**Consultation Response from KC,
Highways Development Management****2025/93098 1a, Church Lane, Newsome, Huddersfield, HD4 6JE****Prior notification for change of use from commercial/business/service to one dwelling****Date Responded: 03/12/2025****Responding Officer: D. Stainsby****Responding Ref: K6-8NW/6**

This application is for the change of use from commercial unit to one dwelling at 1a Church Lane, Newsome,

Drawing  
UD-613

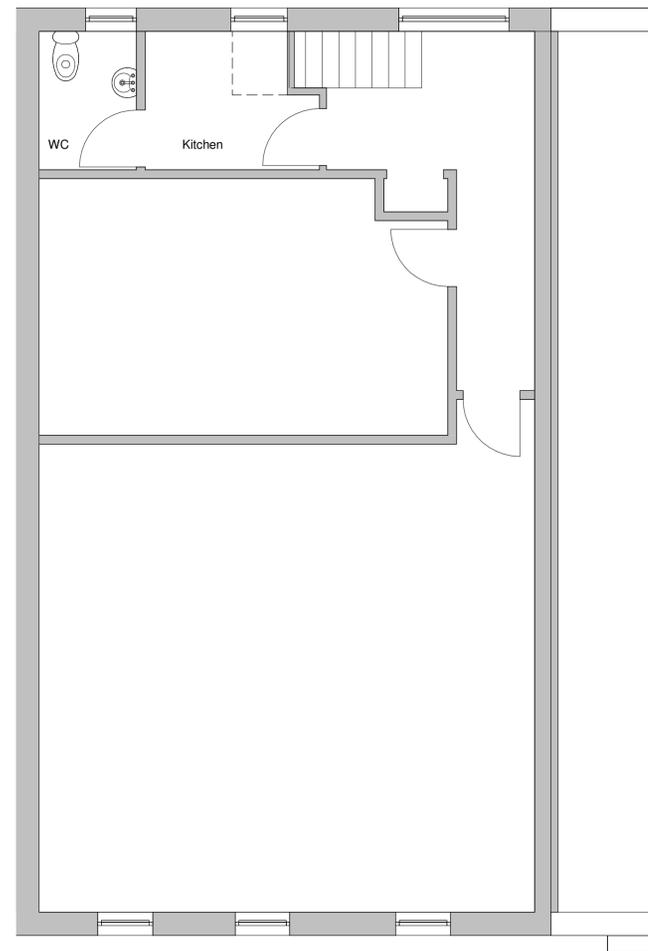
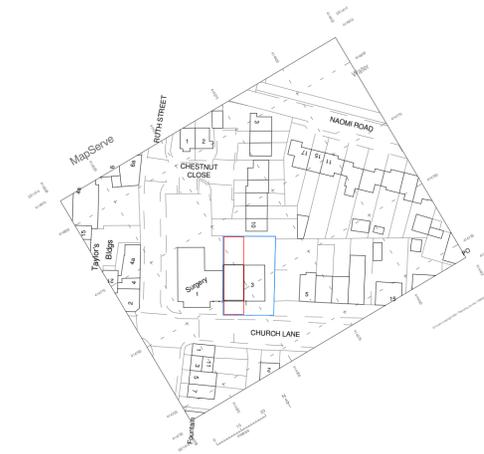
To the rear of the site there is private parking, and it appears that adequate parking can be provided within the site boundary, however we would like to see a drawing clearly indicating that adequate parking can be provided for the dwelling without obstructing access around the site.

No details have been provided regarding the location of bin storage and HDM requests that this is clearly presented on a plan to ensure any parking or access is not obstructed

No objection subject to a revised plan showing a parking space and bin storage.
